Job ID: 2012-10-5166-FAFS  
install supervised fire alarm system

For installation at:  
561 FOREST AVE

**This permit is to install the fire alarm infrastructure only. Additional fire alarm permit(s) shall be required for the tenant fit up(s).**

DATE: 08.29.12
 CHECKED BY: JAD
 DRAWN BY: JAD
 JOB: FAO-12
 SHEET TITLE: FIRST FLOOR PLAN

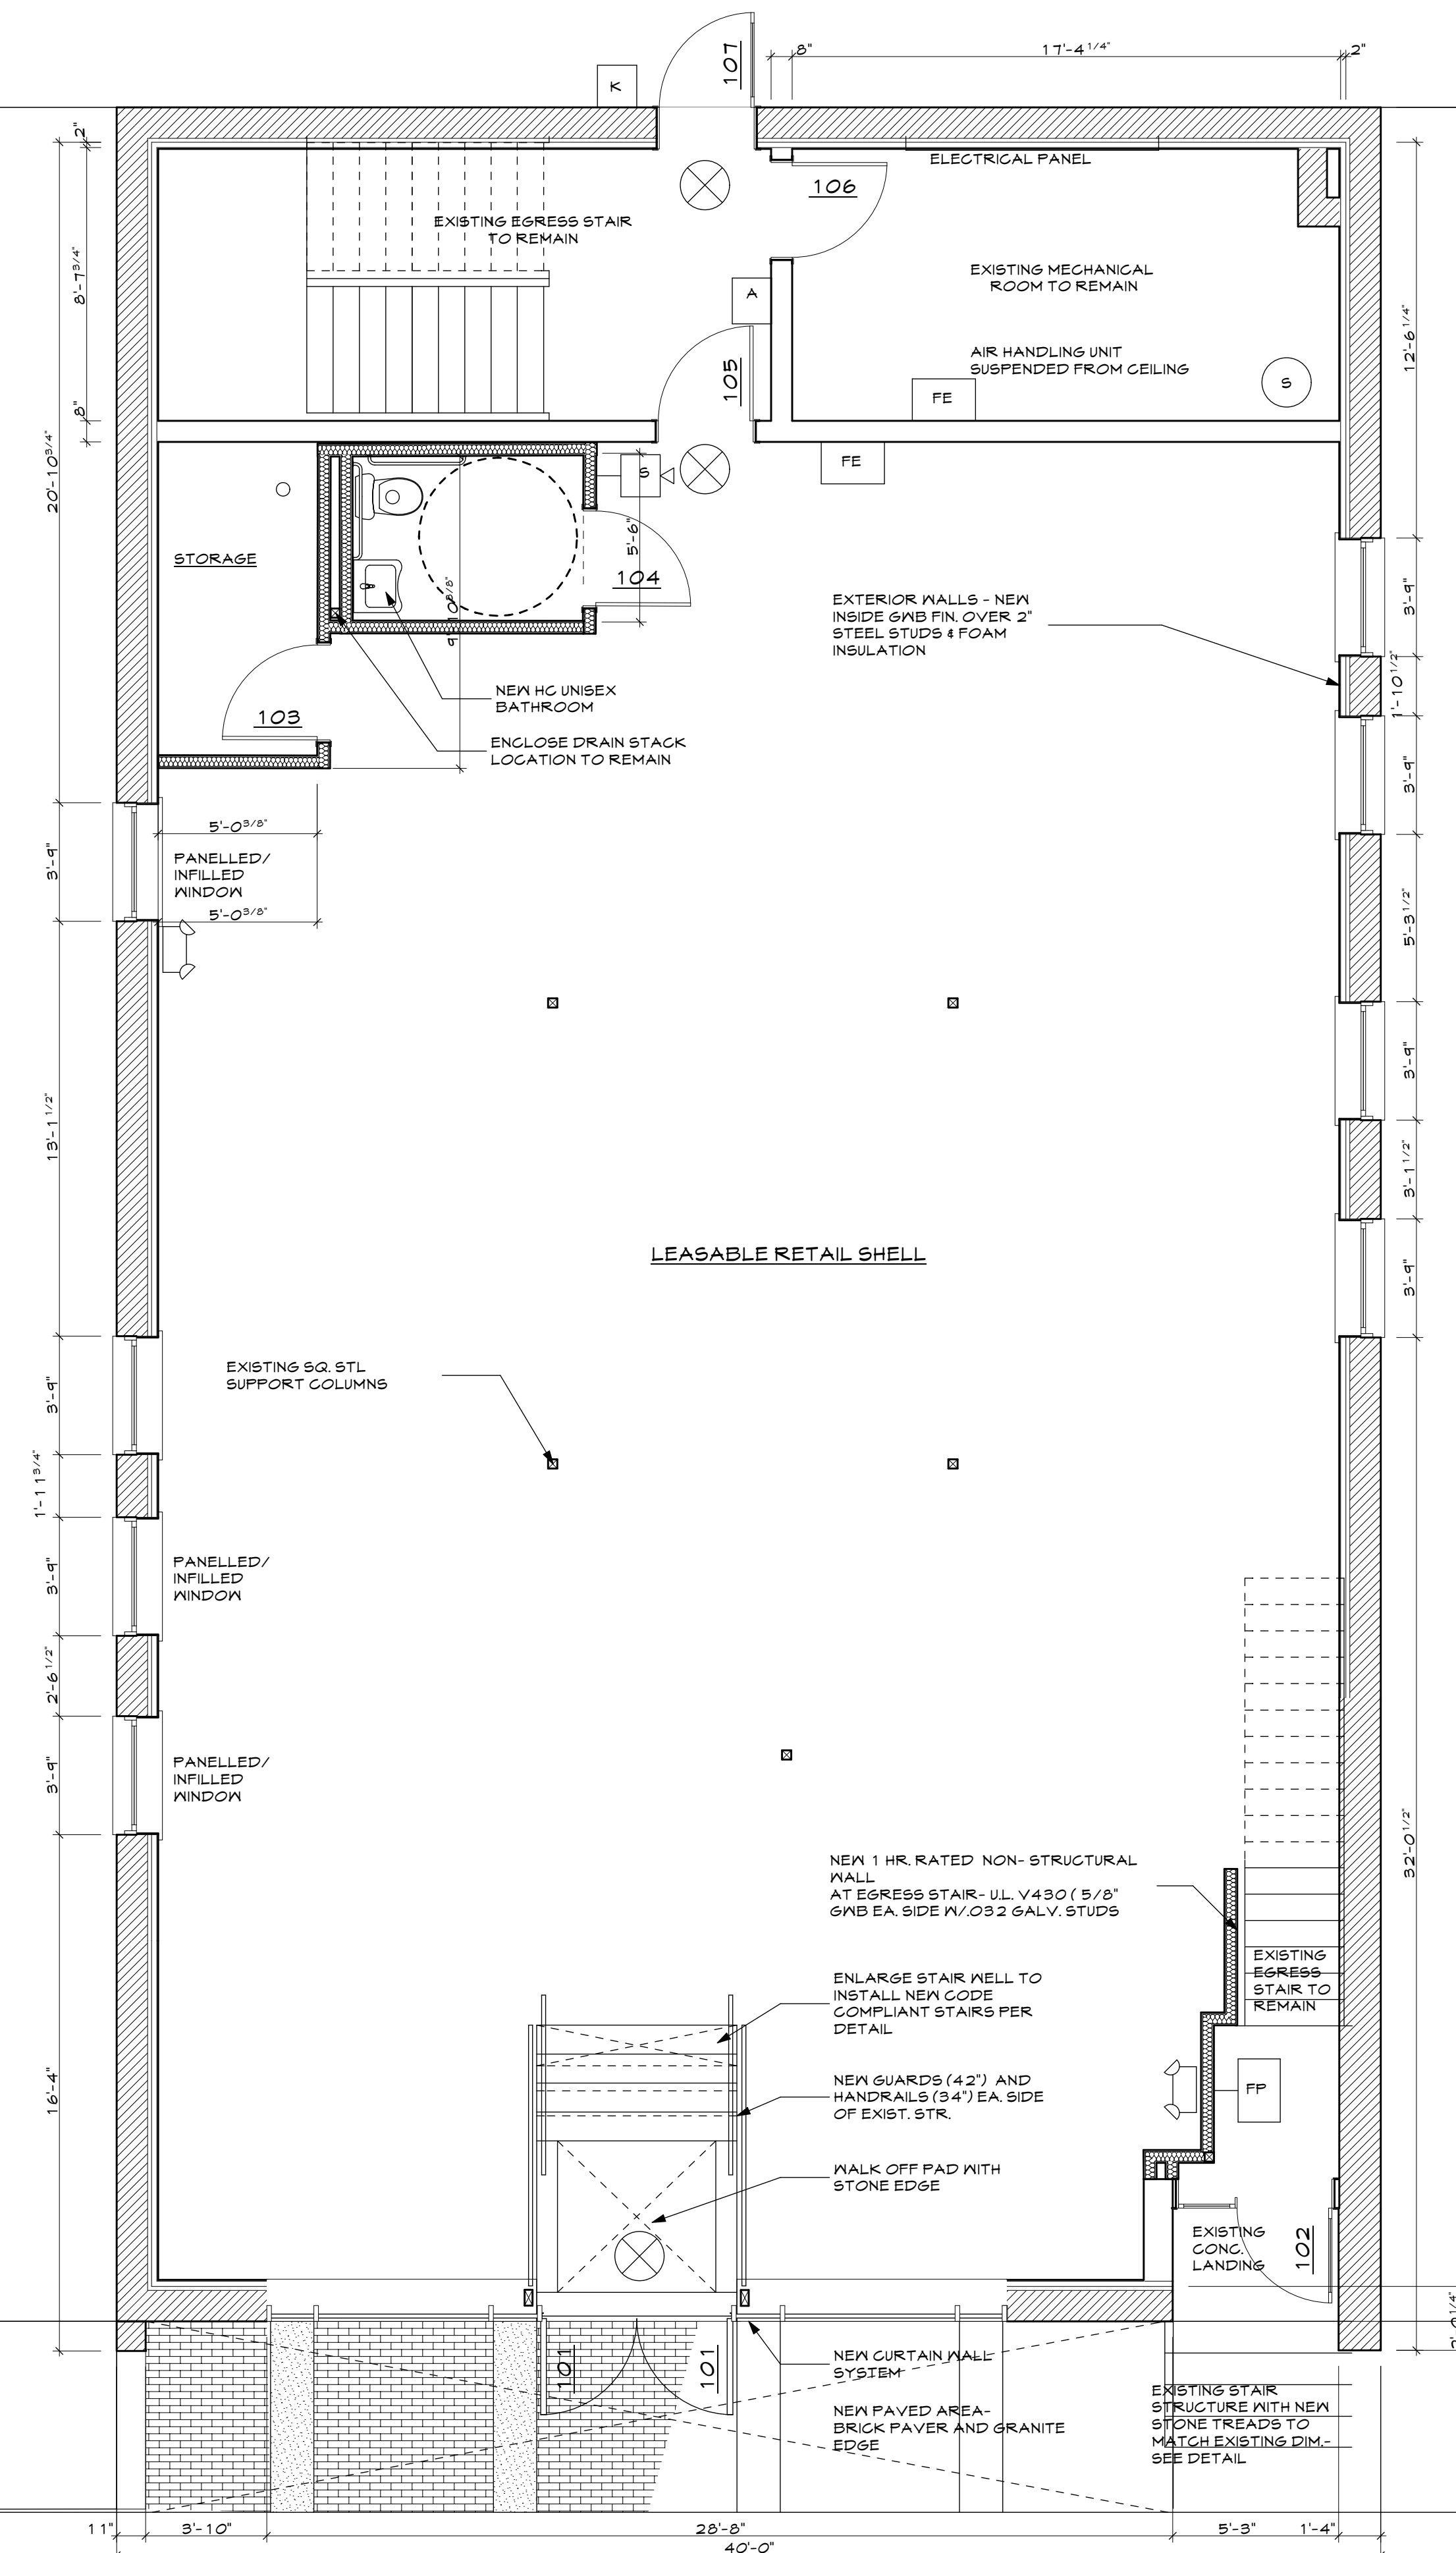
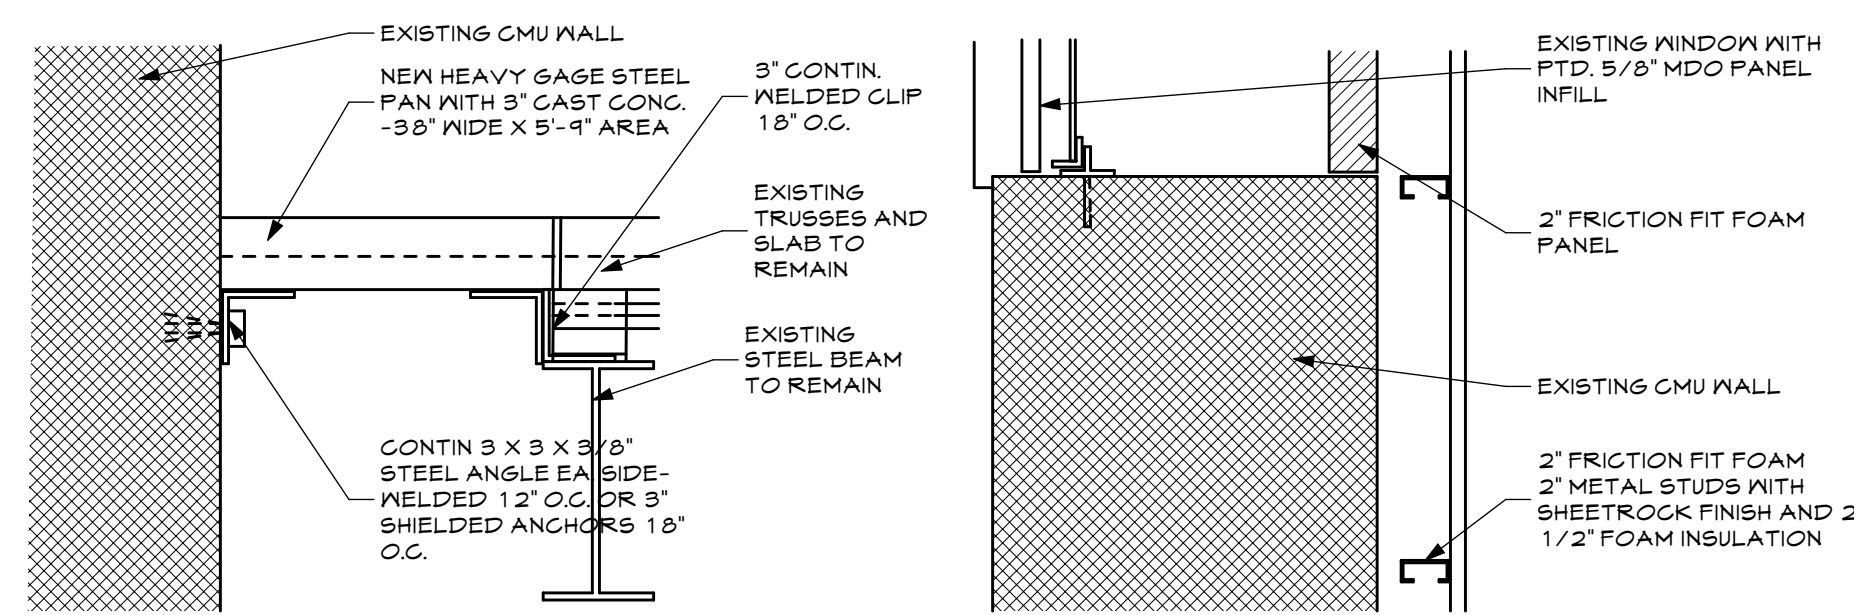
**The annunciator shall be located at the front door facing Forest Ave with a pull station. The pull station for the front stair shall be located on the second floor inside and adjacent to the stair door, not the first floor landing. There shall be no smoke detectors installed in the second floor utility room or kitchen.**
